**Level II Final Site Plan Application**  
**Lot 5 Industrial Way; CBL: 326-C-5**  
**Application ID: 2015-085**

This letter and attached material are provided in response to the conditions of approval regarding the above referenced project as contained in the Planning Board Report dated July 30, 2015. The following numbered responses correspond to the action items within the report:

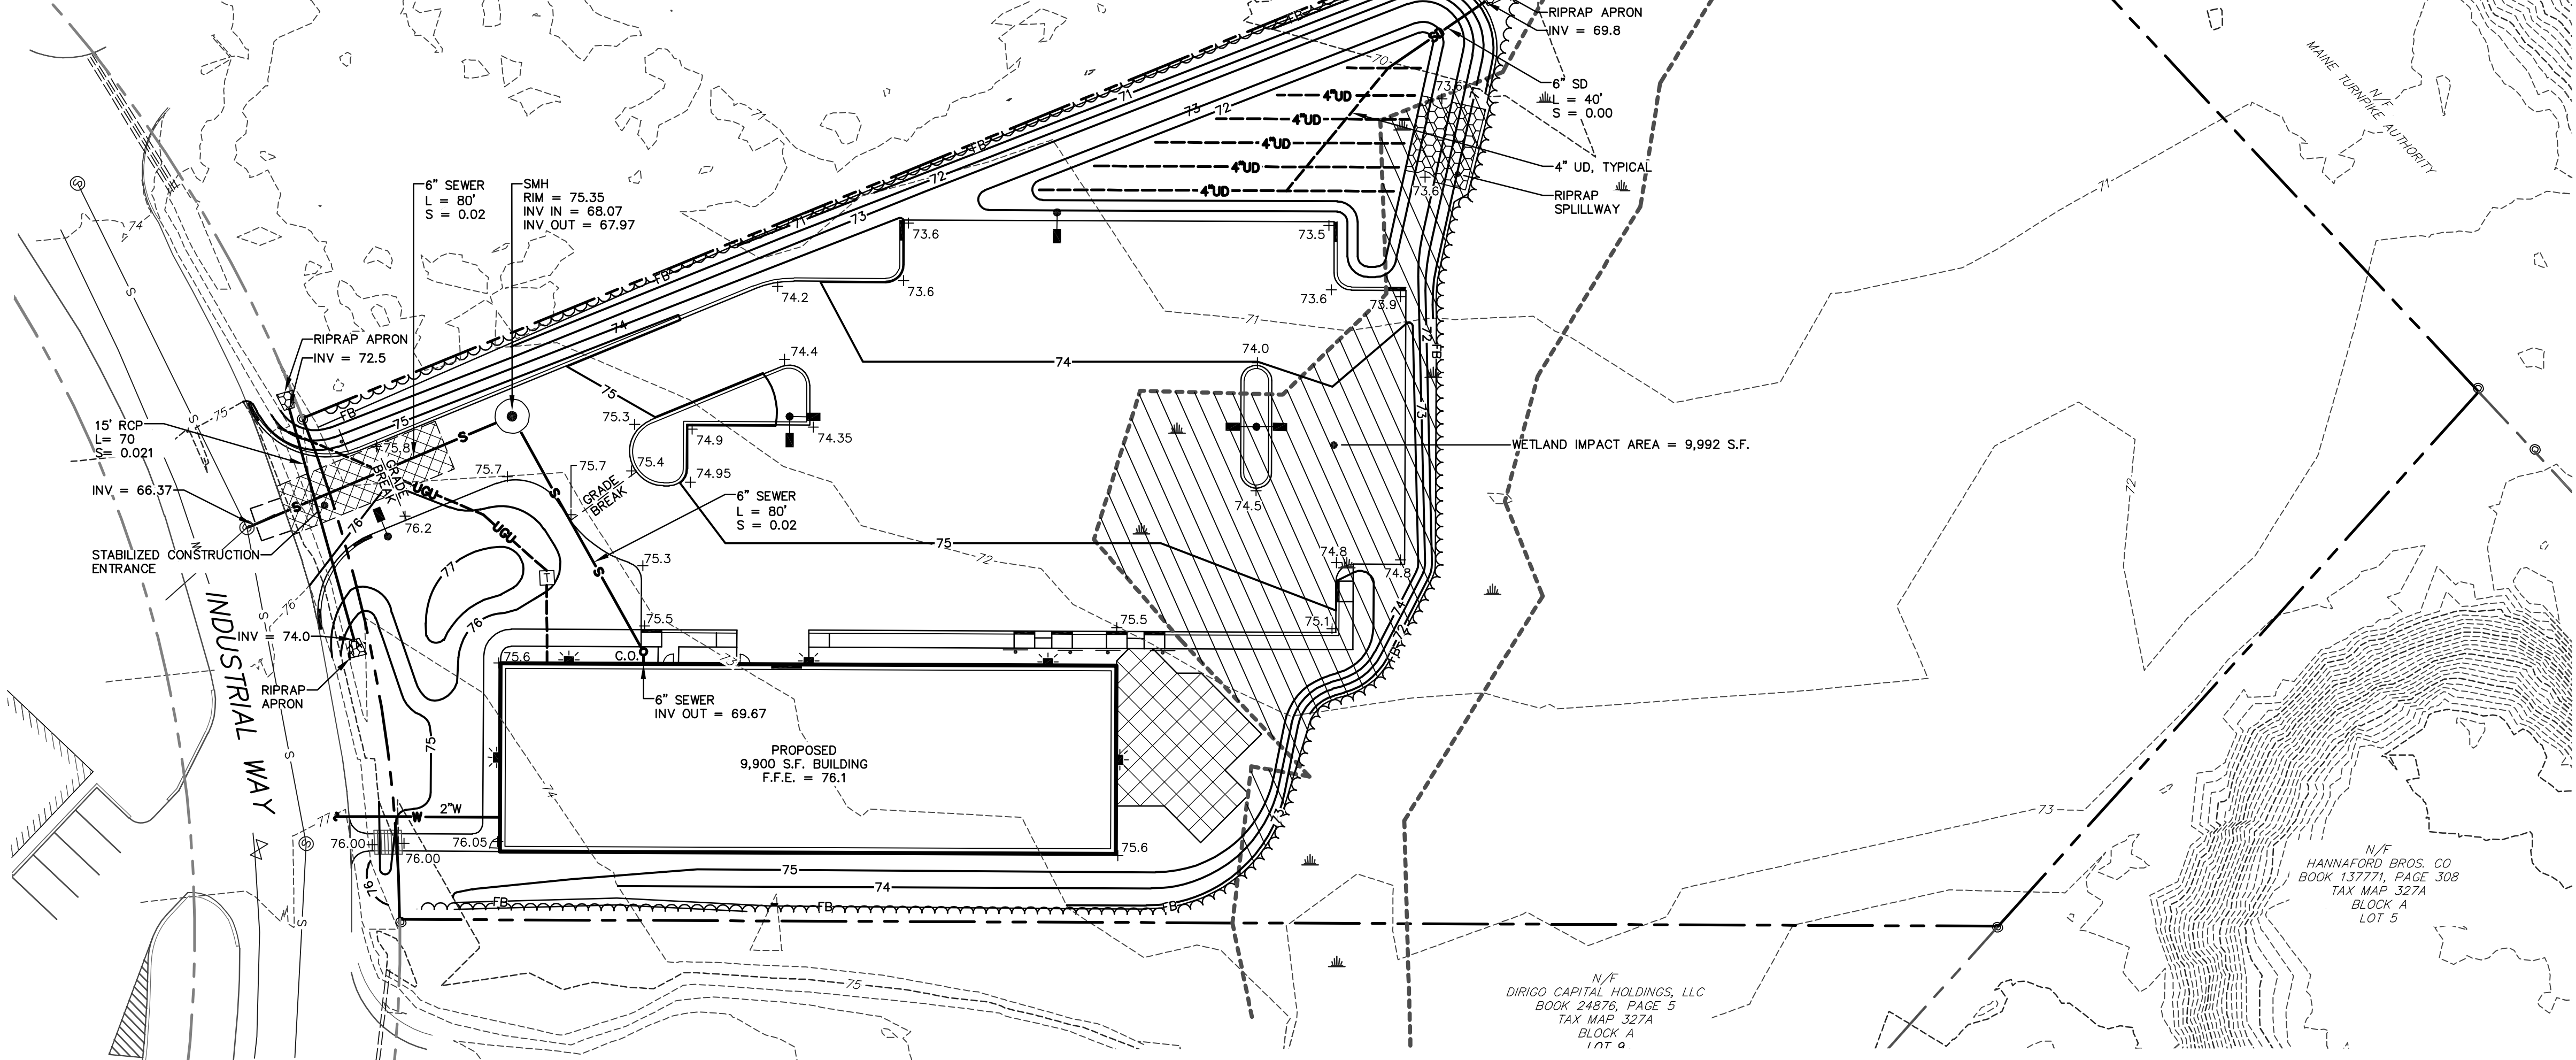
- iv. The proposed driveway culvert has been revised to Reinforced Concrete Pipe in accordance with Section 2.5.2 of the City of Portland Technical Manual. The discharge invert elevation is restricted by the existing elevation of the downstream ditch. As depicted the culvert has approximately one foot of cover at the edge of driveway pavement. The upstream invert has been lowered by six inches to provide approximately one foot of cover at the edge of driveway pavement.
